Appeal NO: ABP 314485-22Defer Re O/H ☐Having considered the contents of the submission dated/ (received) 02/04/2024
fromDeirdre and Paul Nolan I recommend that section 131 of the Planning and Development Act, 2000
be/ (not be invoked) at this stage for the following reason(s): no new material issuesE.O.: Pat BDate: 18/04/2024

RE: Case Number ABP- 314485-22 Relevant Action Application Dublin Airport

Figure 3.1 – Regulatory Decision, Third Condition.
Residential Sound Insulation Grant Scheme (RSIGS) - Initial Eligibility Contour Area - June 2022

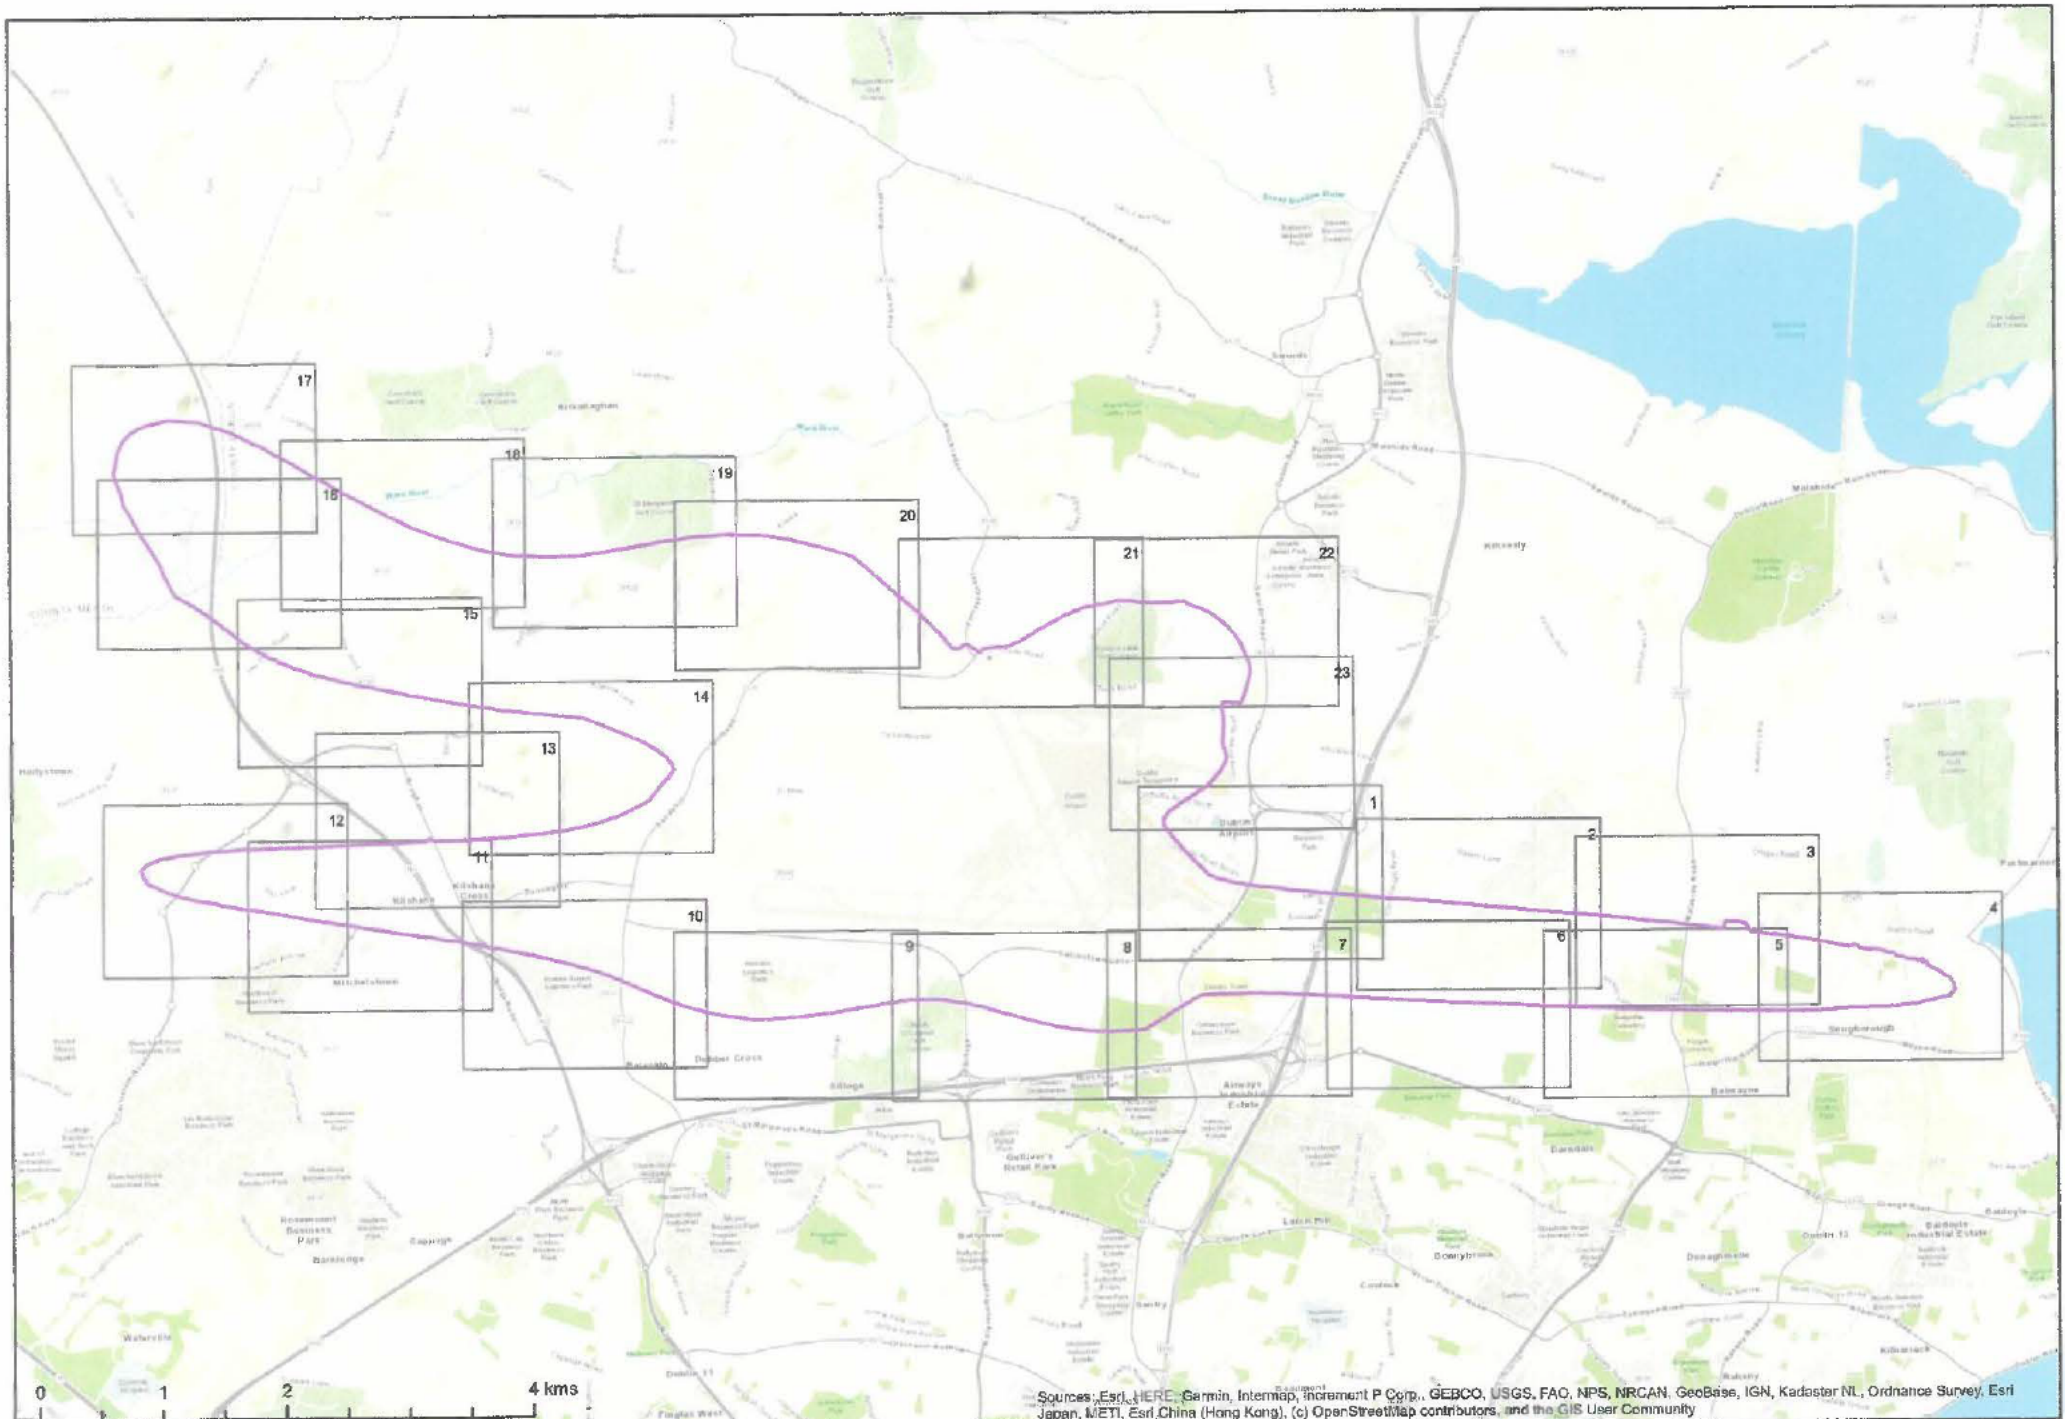
1. We are shocked to see that the noise contours have extended hugely into our community and that a very significant number of dwellings are now included within the noise eligibility contours. Firstly, we note that there was no notice of this fact in any of the planning notices for this application to date. Many of our neighbours who thought they were not affected by this application are now inside these contours but yet were never publicly notified until they attended a public meeting held by St Margarets /The Ward residents' group who explained this to all of us. None of the newspaper or site notices informed the public. Secondly, the people who now know they are within the contours have not been given the opportunity to make a submission/observation as they do not qualify because they did not make a submission previously as they thought they were unaffected. An Bord Pleanála did not give a public notice of this significant additional information. The above is totally unacceptable and unjust to the communities affected.

2. We note that the correspondence from Tom Phillips & Associates refers to the ANCA Regulatory Decision regarding eligibility to the noise insulation scheme and suggest that the change in contours is as a result of their assessing that the increased area is as a result of them considering this new area which contains dwellings to having "very significant" effects. We note that the DAA have never carried out significant test criteria within any of the EIAR they have submitted and therefore they have not met with the EIA directive. This is a fundamental flaw in the assessment as the EIA directive is clear, all significant impact on environment must be identified, quantified and mitigation proposed. That has not happened to date. For areas under the North Runway this involves comparing the scenario with no flights from the North Runway to a scenario where there will be night flights. This has not been done.
